Your ref:
Our ref: 23/00934/F
Please ask for: Miss Joanne Wren
Direct dial: 01553 616233
E-mail: borough.planning@west-norfolk.gov.uk

Details: **Construction of single storey extension at Chilver Lodge Chilver House Lane
Bawsey King's Lynn Norfolk**

SIDE ELEVATION AS PROPOSED [SW]
1/100

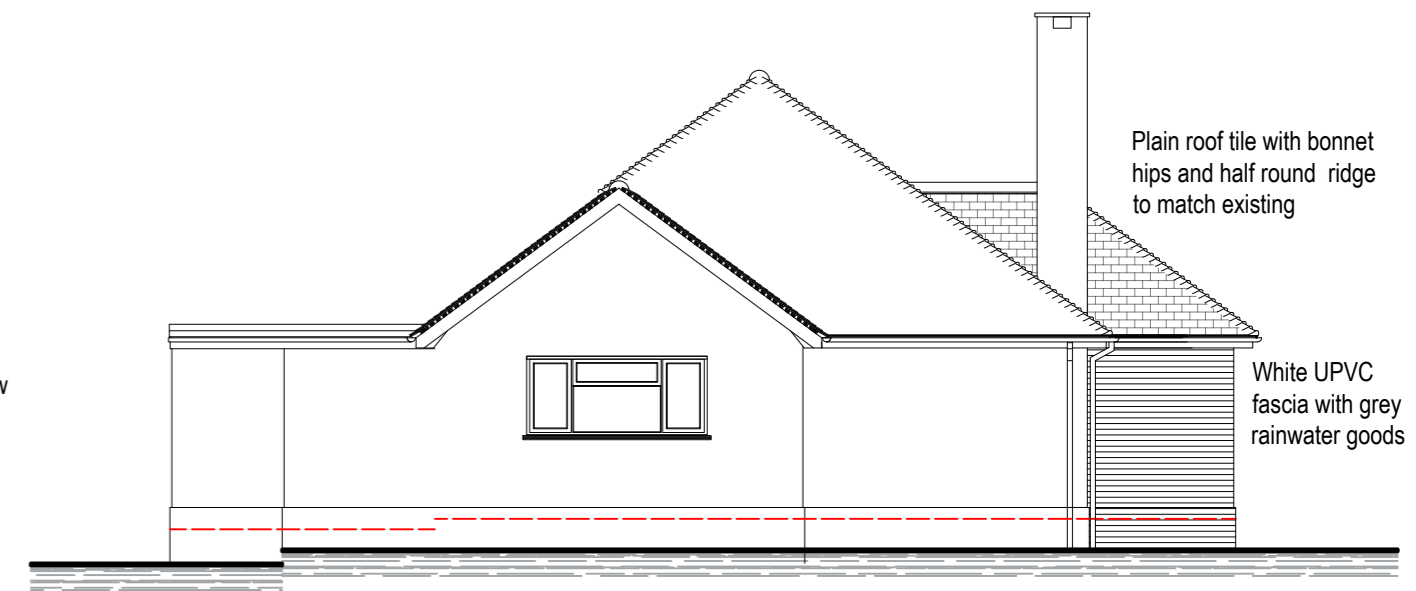
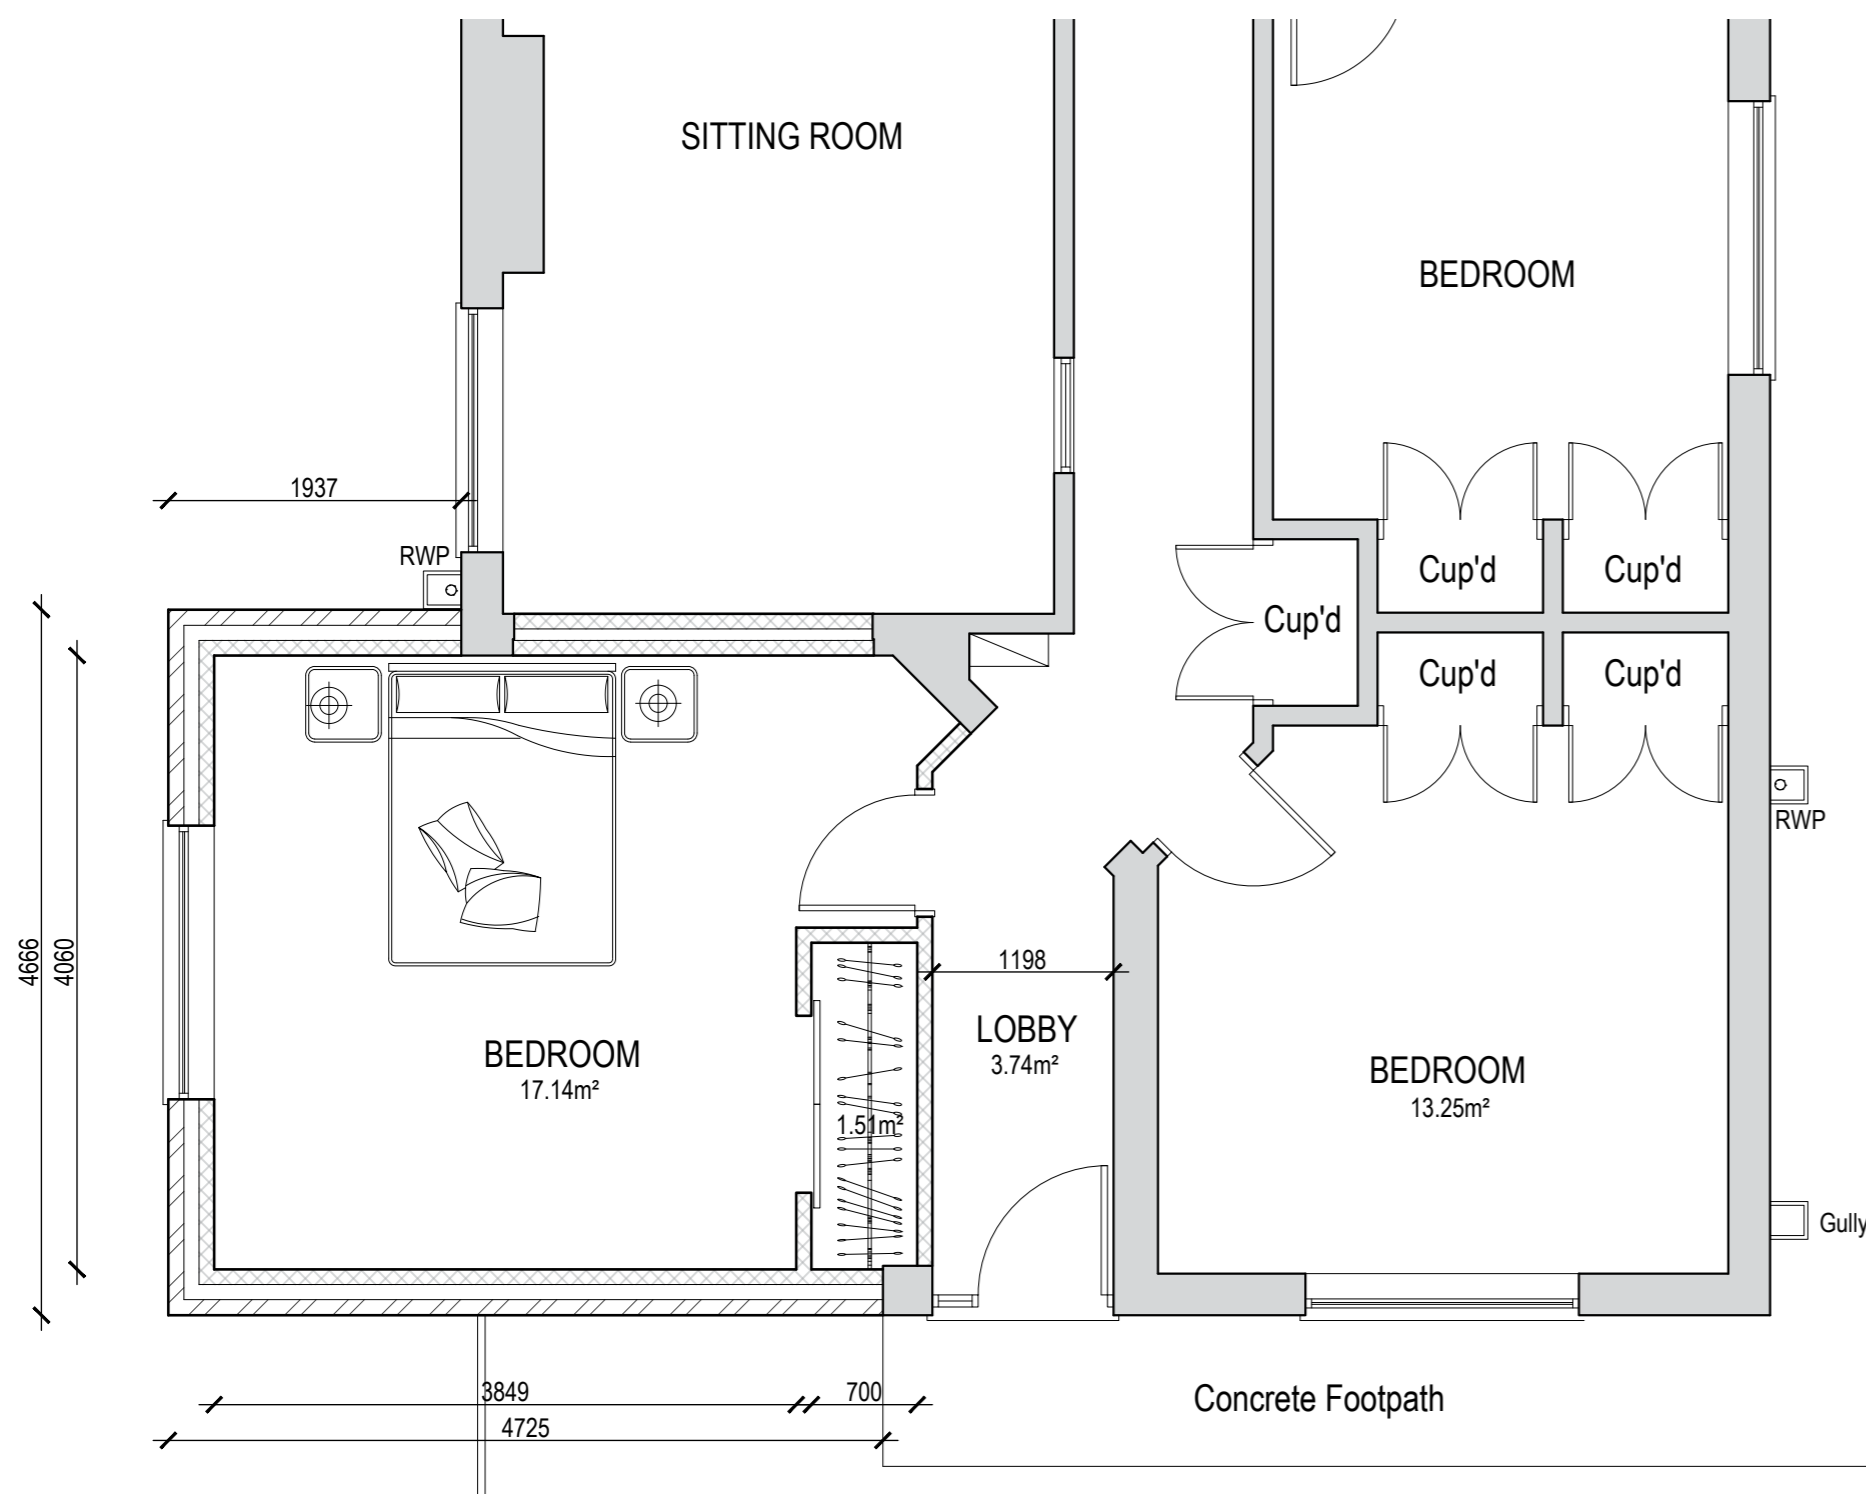
1. There is a window shown on the side elevation that is not on the floor plans, please amend and resubmit these.
